MEMORANDUM

TO: Bill Needleman, Planner
FROM: David Senus, P.E. & Ashley Auger, E.I.T.
DATE: May 15, 2012
RE: Jordan's Site Mixed Use Development, Level III Final Site Plan/Subdivision Application

Woodard & Curran has reviewed the Level III Final Site Plan/Subdivision Application for the Jordan's Site Mixed Use Development located at 203 Fore Street in Portland, Maine. The project consists of development of a five story mixed use condominium building with retail space, office space, and residential units.

POST DEVELOPMENT WATERSHED PLAN
 OF:
HOTEL, RESTAURANT & RESIDENCES - OLD PORT
 207 & 209 FORE STREET
 PORTLAND, MAINE
 FOR:
OLD PORT HOSPITALITY, LLC
 11 CORPORATE DRIVE
 BELMONT, NH 03220

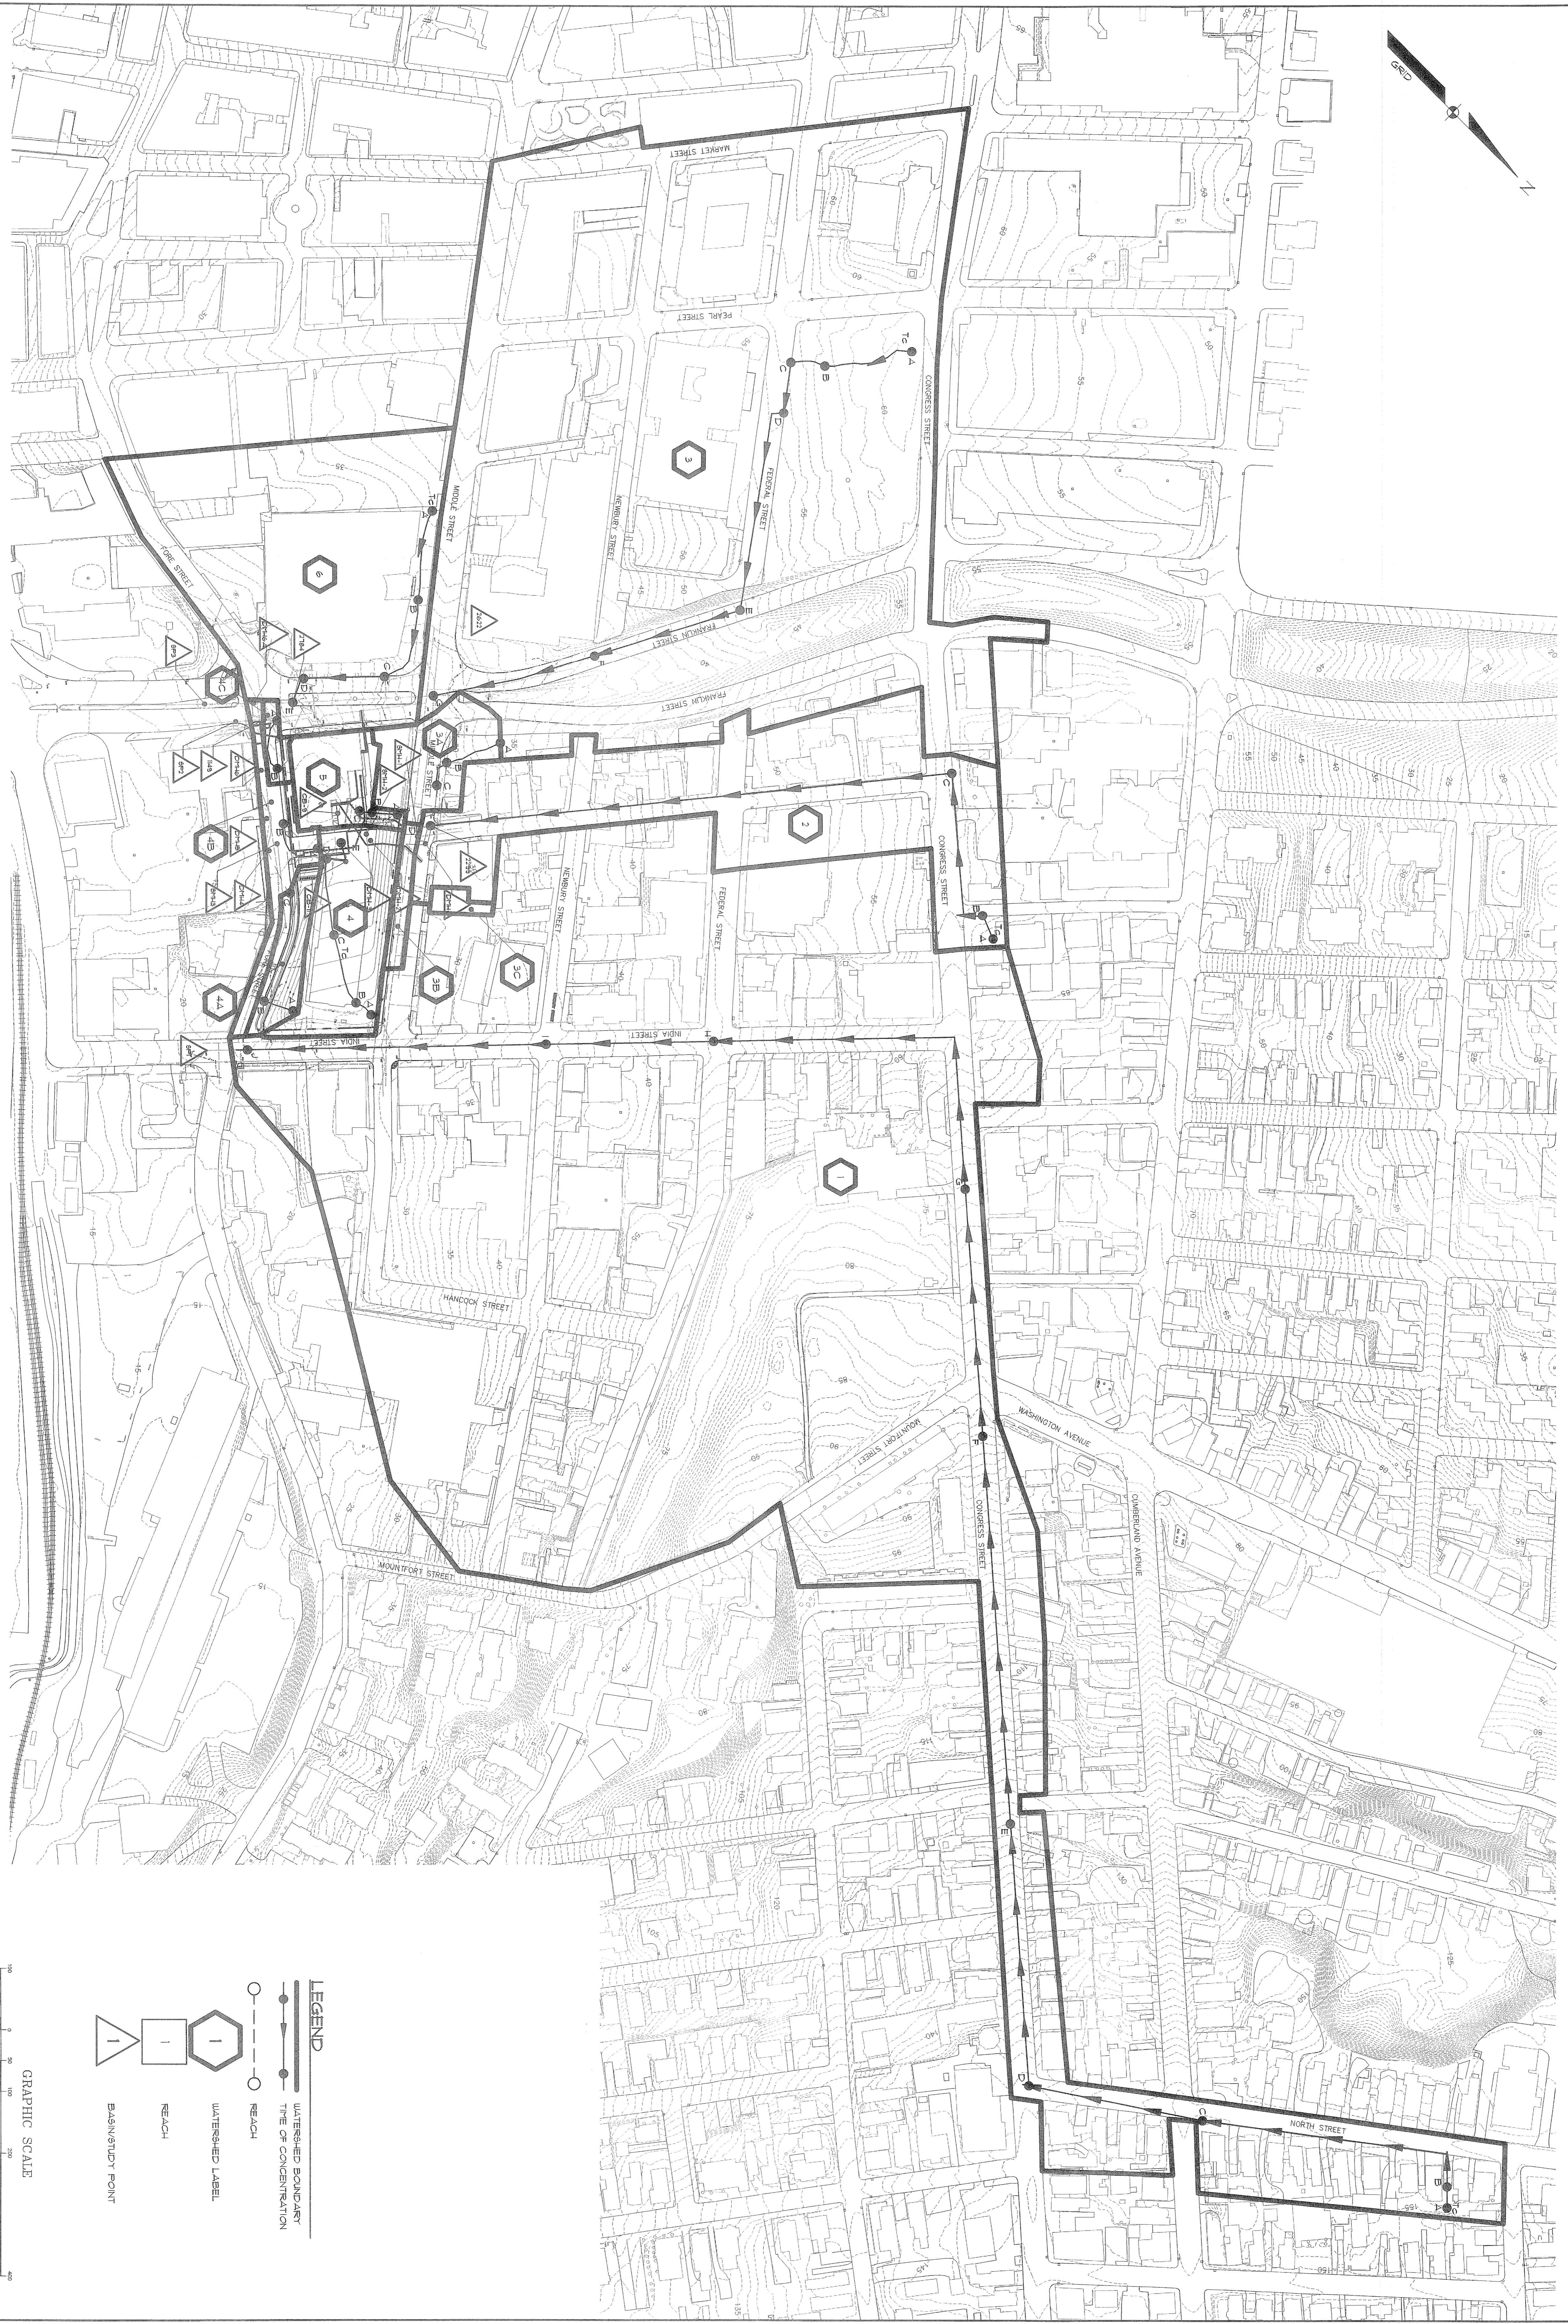
- c) Flooding Standard: The Applicant has submitted a detailed stormwater model indicating that post-development runoff rates for the project will exceed pre-development conditions during certain storm events. The model is noted to be an addendum to the Stormwater Management Plan prepared by Sebago Technics for the site, dated February 16, 2010. The Applicant should verify that the City's existing stormwater conveyance infrastructure has adequate capacity to convey the stormwater runoff from the site during the design storm events.
